RE: Take 5 Oil Change
2030 Gibson Blvd. SE
Traffic Circulation Layout
Engineer's Stamp 08-28-23 (M15-D021E)

Please find below our responses addressing the City of Albuquerque TCL 1st Submittal Review comments for the proposed project located at 2030 Gibson Blvd. SE.

## C1.0

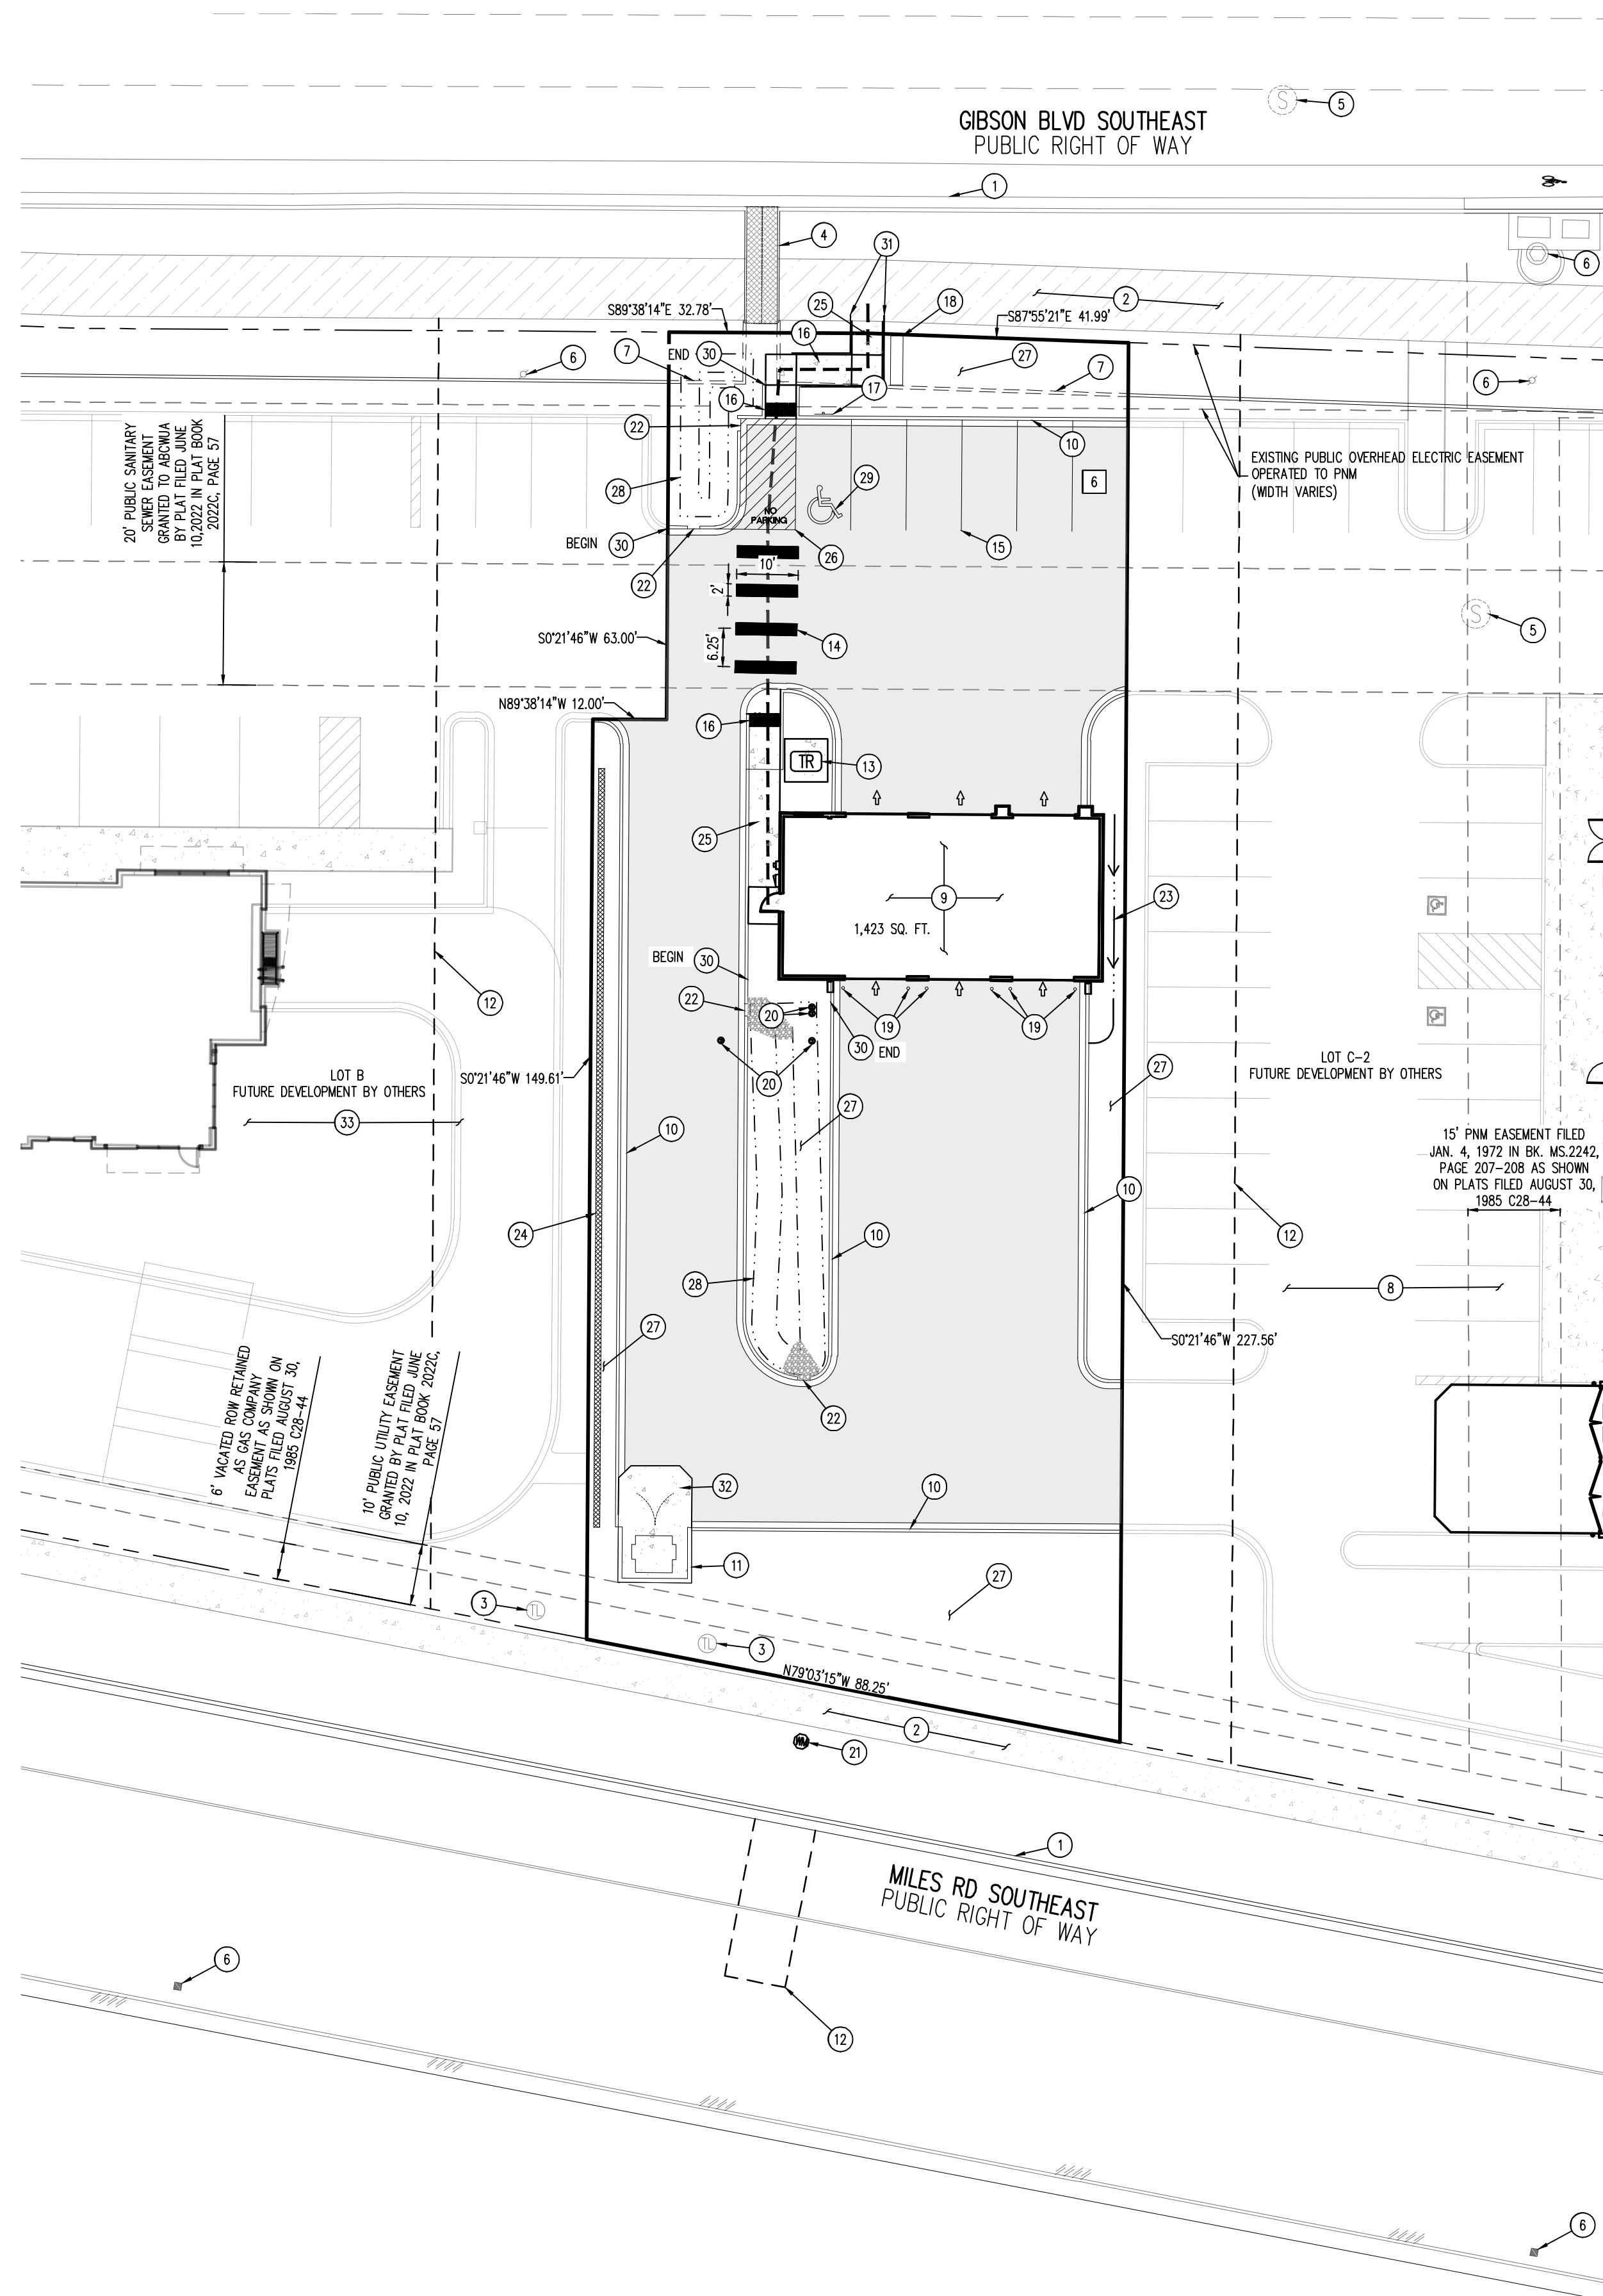
5. Sheet C1.4 shows an ADA handrails details. Please clarify the location of the proposed handrails.

6. The ADA accessible parking sign must have the required language per 66-7-352.4C NMSA 1978 "Violators are subject to a fine and/or towing." Please call out detail and location of signs.

Response: Please see schedule note 31 on sheet C1.0 for the handrail locations.

Response: Please see schedule note 17 on sheet C1.0 for the sign locations and detail listing.
